Our Ref: R/2025/4/A
File No: 2025/229041
Your Ref: SSD 79316759

Advice on EIS – Concept Proposal for Mixed Use with Affordable Housing – 45-53 Macleay Street, Potts Point – SSD 79316759

Thank you for your correspondence dated 1 April 2025 inviting the City of Sydney Council (“the City”) to comment on the proposal at the abovementioned address. The application proposes a concept envelope for a building approximately 50.05m in height (13-storeys) comprising a mix of market and affordable housing and commercial uses.

Drawing Name
FLOOR PLAN L1

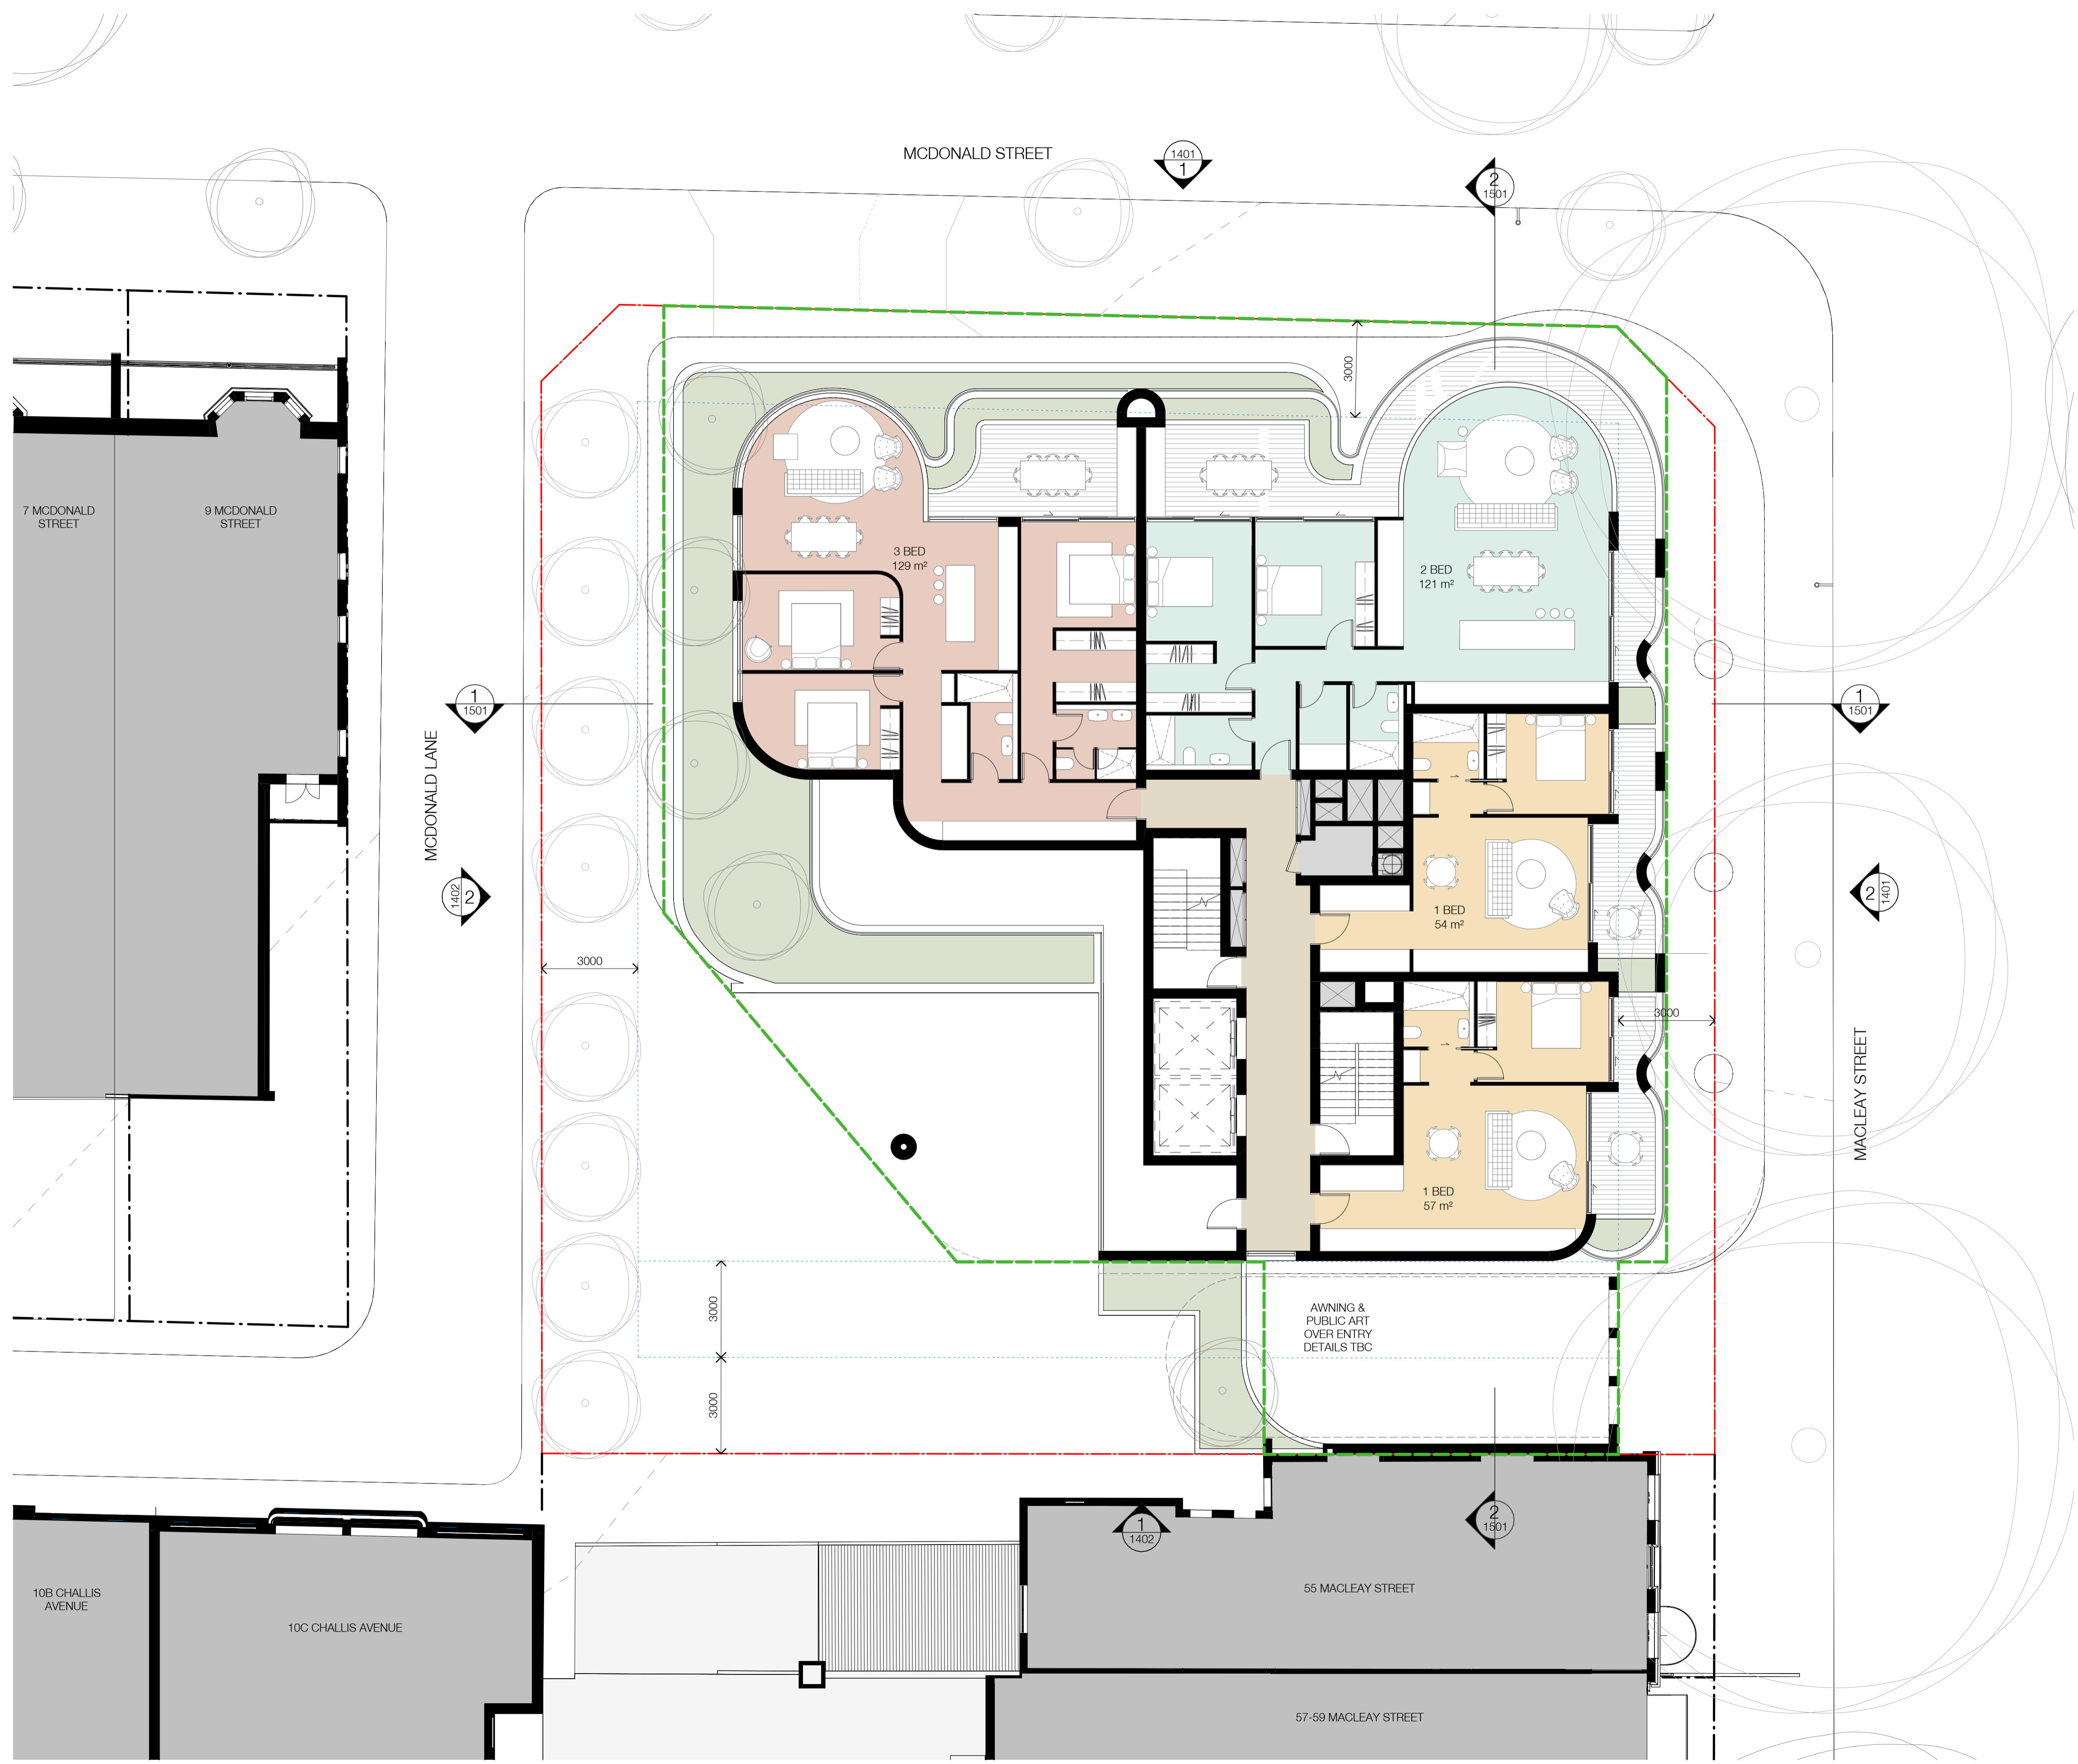
- Rooms with no direct access to light and ventilation should only be used for storage (the study of L4-10's NE 3-bed; L11's and L12's NE 3-bed; L1-L2 NE 2-bed)
